Harnett County

Permit Number: **BCOM2510-0007**

Description: **Used Car Sales at 50x100 Existing Building**

LIST OF REVIEWS

LIFE SAFETY PLAN FOR:
C3 PRE-OWNED LLC

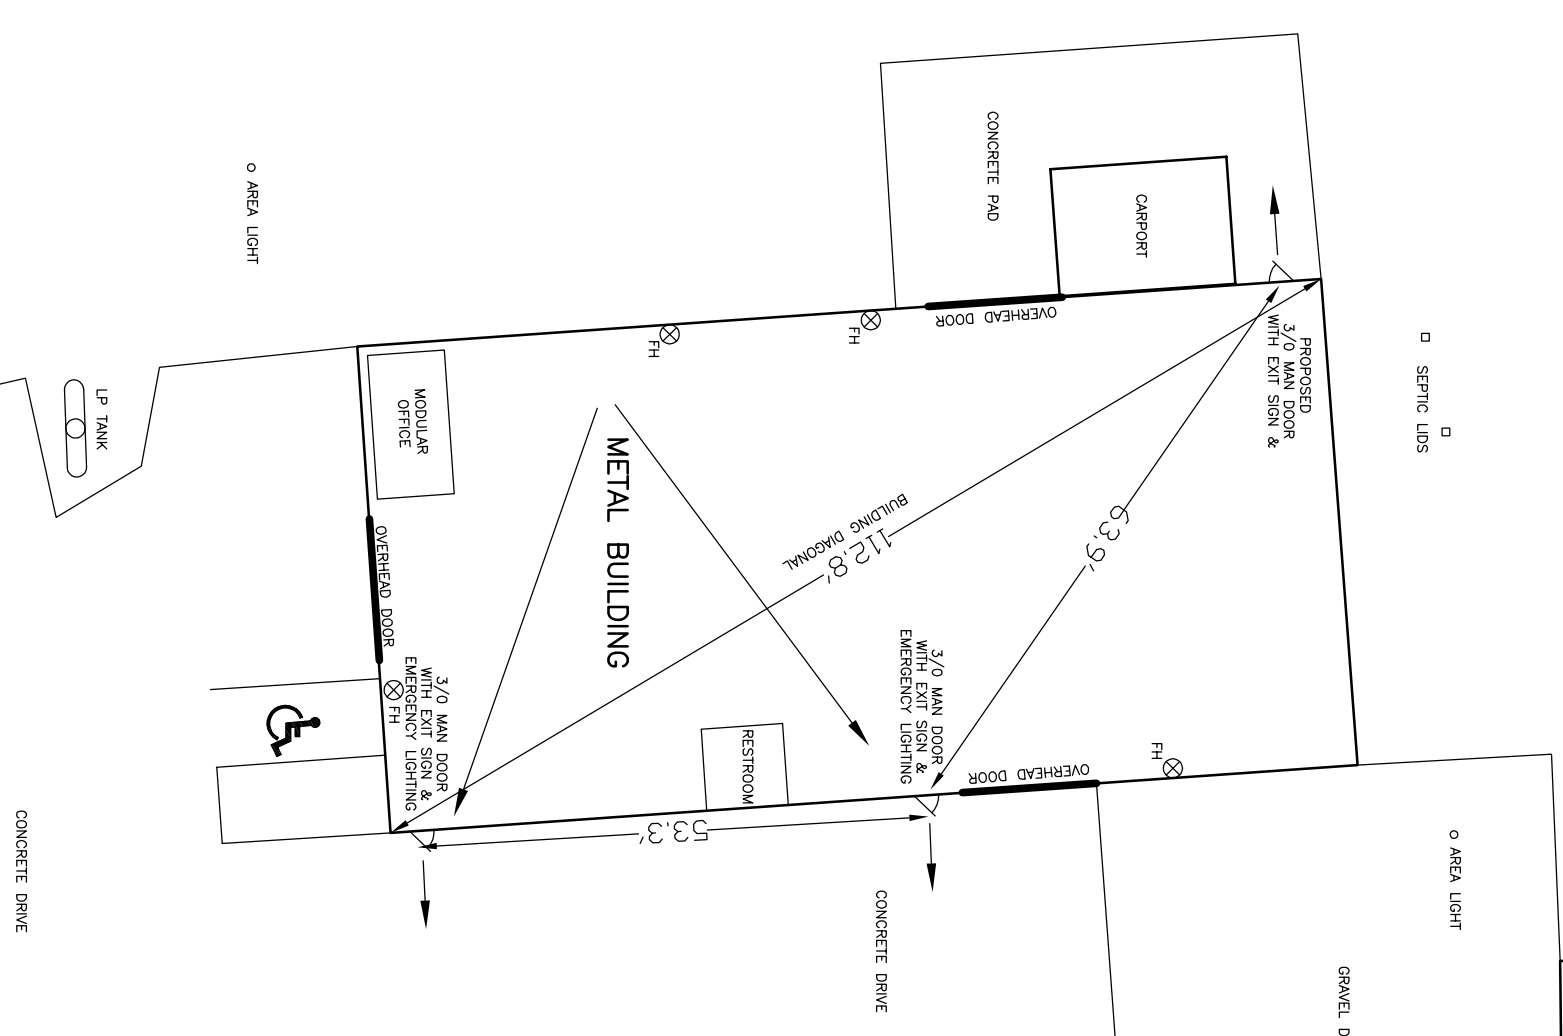
SENT DATE	RETURNED DATE	DUUE DATE	TYPE	CONTACT	STATUS	REMARKS
Review Group: 1ST PLAN REVIEW						
10/21/2025	10/24/2025	11/4/2025	RESIDENTIAL BUILDING	Brad Sutton	DISAPPROVED	
Notes: Exits shall be 57 feet apart based on diagonal measurement of building						
10/21/2025	10/23/2025	11/4/2025	FIRE MARSHAL	Roger Sullivan	DISAPPROVED	see notes
Notes: Life safety plan does not indicate diagonal distance of interior of building, occupancy load calculations & fire extinguishers placement. Using provided scale, the distance between both exits do not meet remoteness requirements, they must be a least one half of the diagonal distance of the interior of the building.						
Review Group: AUTO						
10/14/2025	10/21/2025		COMMERCIAL INTAKE	CP Bucket	APPROVED	
Notes: 10/24/2025						
10/24/2025			RESIDENTIAL BUILDING	Building Bucket		
Notes:
